Temperature Controlled Warehouse Facility (SSD-8586218)
Response to Submissions

Attachment A: Request for further information

4 SIGNAGE LOCATION PLAN 1 : 750

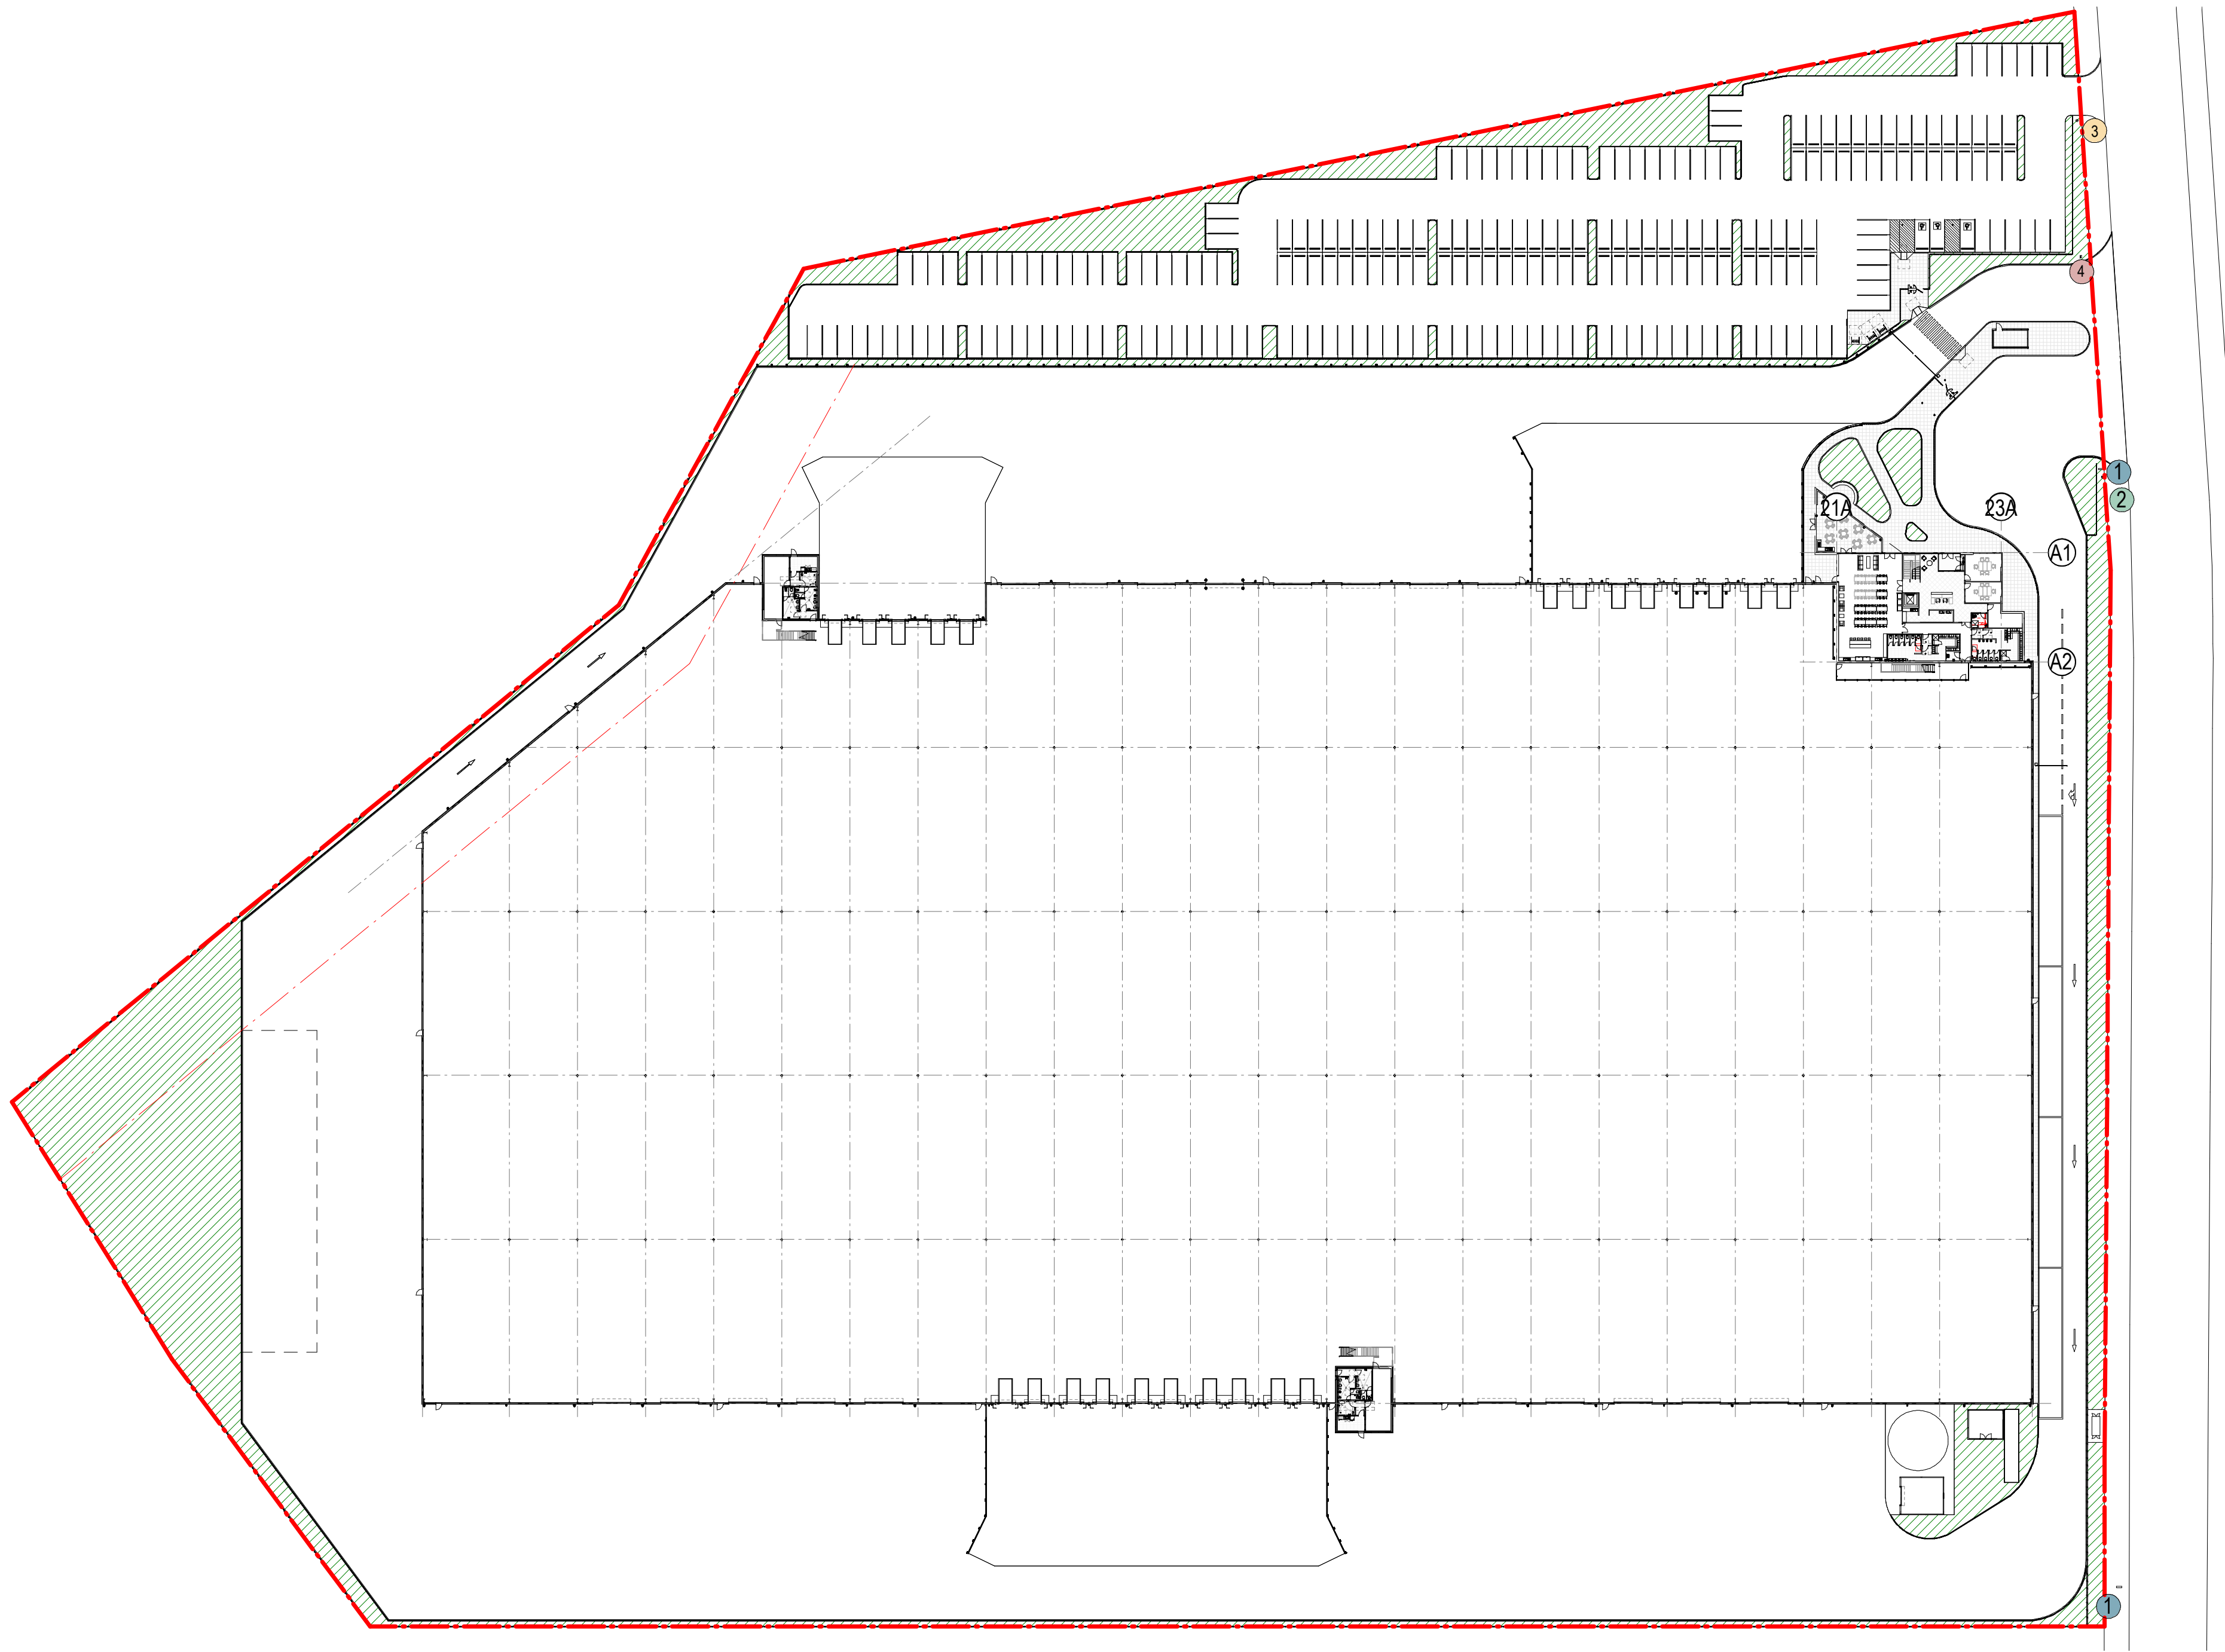
It is acknowledged that a condition to provide flexibility on signage as part of the development was requested in the EIS, with generic signage shown on the provided drawings. To ensure any future signage changes are appropriate, the condition is not supported. As such, please provide drawings detailing the specific signage proposed.
